**Consultation Response from KC Environmental Health – Pollution & Noise Control
2020/90450 Land at, Owl Lane, John Ormsby V C Way, Dewsbury, WF12 7RQ**

Erection of restaurant with drive-thru, car parking, landscaping, play frame, customer order displays and associated works.

**Date Responded:
23rd March 2020**

**Responding Ref:
WK/202005000**

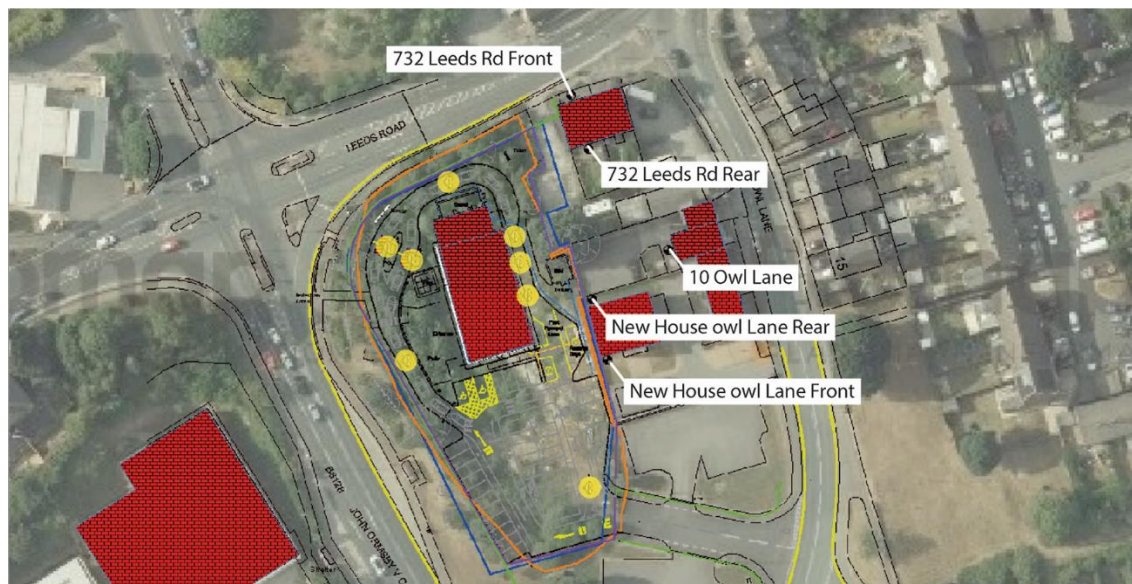
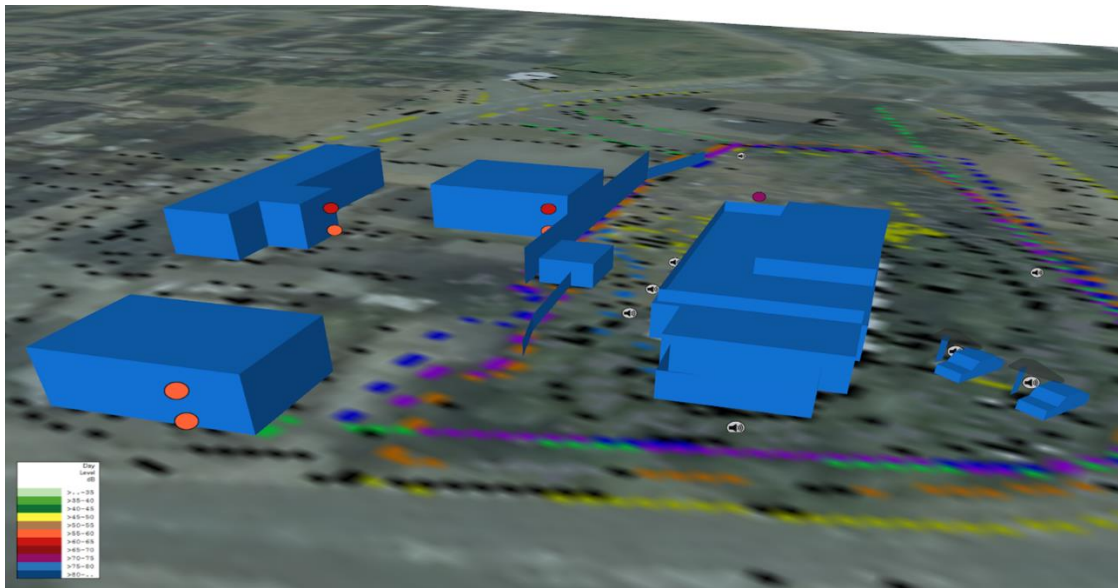
3. *There is no accepted methodology for undertaking noise impact assessments for car park noise, customer vehicle noise, resulting in a variety of highly differing methods being used. The noise levels generated by the customer vehicle movements at the proposed development have been predicted in this instance, have been calculated*

by way of “the overall sound level created by a single vehicle, which will take approximately 2 minutes to arrive, order, collect and leave the drive thru lane, before being multiplied up for the number of vehicles predicted to pass through the drive thru lane in each hour, added to the number of vehicles using the car park”. This has been used to predict an hourly $L_{Aeq,1hr}$. It appears that the customer vehicle (Activity) noise impact has been predicted by using the above Activity $L_{Aeq,1hr}$, and calculating the increase to the ambient noise climate.

- a. This method is not acceptable for the purposes of determining the noise impact of customer vehicles (due to the averaging time) – a more appropriate method would be to use the $L_{Aeq, T (activity)}$ for comparison, as this will provide a more accurate assessment of the actual noise impact at the nearby receptors. The use of $L_{Aeq,1hr}$ hides the actual noise levels experienced.

The 3D image below shows a small speaker symbol representing the position of the slam in Bay 0;

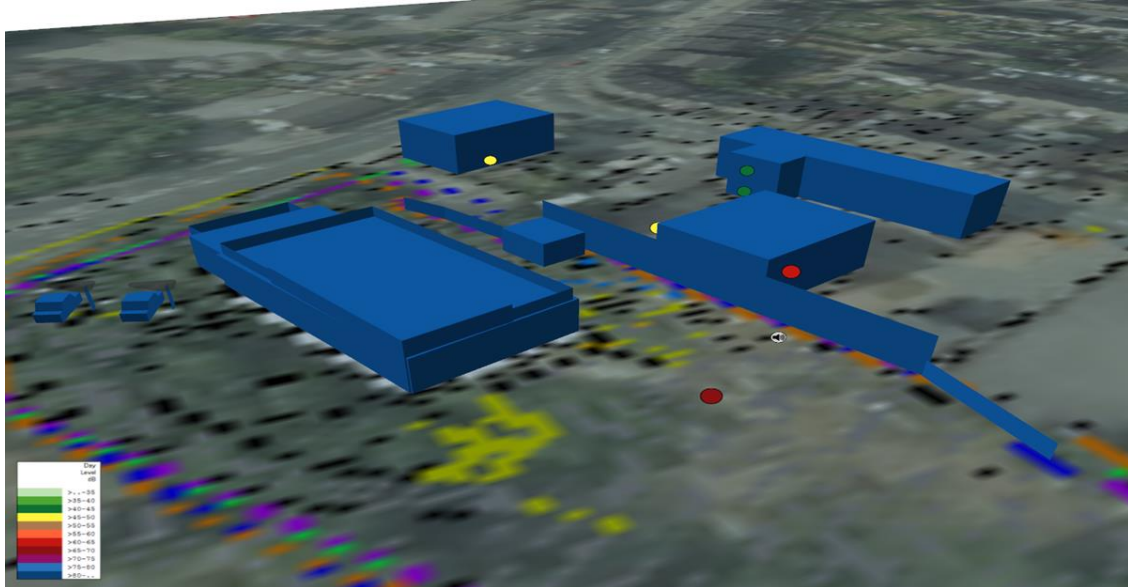
4. The use of bay 0, the closest parking bay to the nearby receptors may not provide for a worst case scenario assessment of the noise impact of car door slams due to the close proximity of the source to the acoustic fence - it may provide a shadowing effect. The image on P.23 of the assessment shows the barrier in 3D in relation to the receptor, but it also indicates that it will provide a good barrier to noise sources in bay 0. It is not clear if this represents worst case scenario, and additional data for the other parking bays should be provided.

The image below shows the approximate location (small speaker symbol) of the delivery vehicle in its off-loading position;

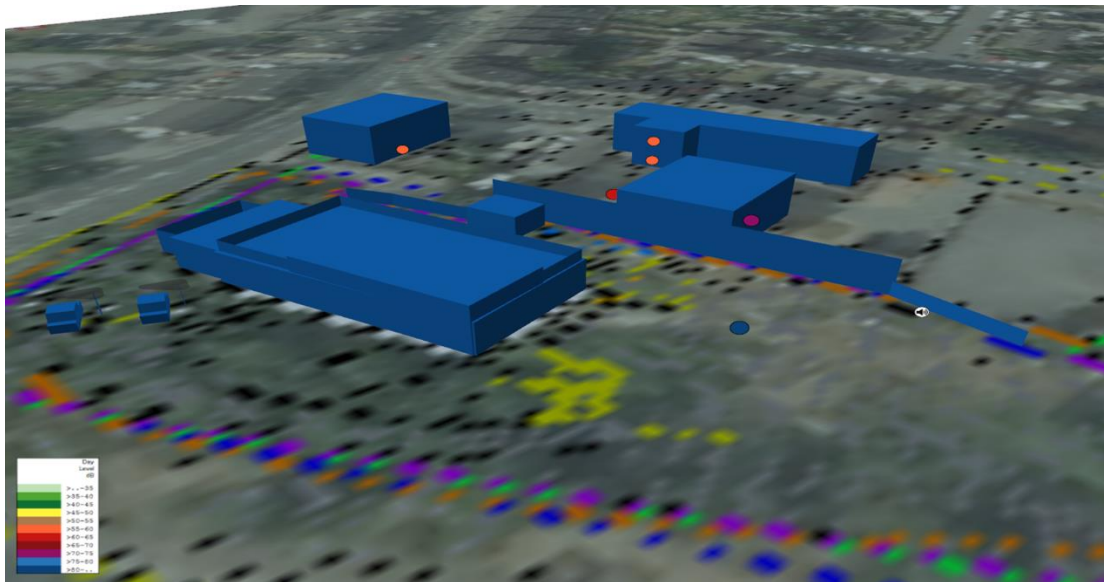
5. I accept the findings of the BS4142 assessment, that noise from deliveries will not be significant. However, the noise assessment appears to only consider the noise of the delivery vehicle engine and chiller units. Deliveries can cause significant disturbance from noise associated with manoeuvring vehicles (reversing alarms, tailgate lifts) and from cages rattling and banging. A condition limiting hours for deliveries is therefore appropriate.

There shall be no deliveries to or dispatches from the premises outside the hours of 09:00 and 22:00 Monday to Saturdays. No deliveries shall take place on Sundays or Bank Holidays.
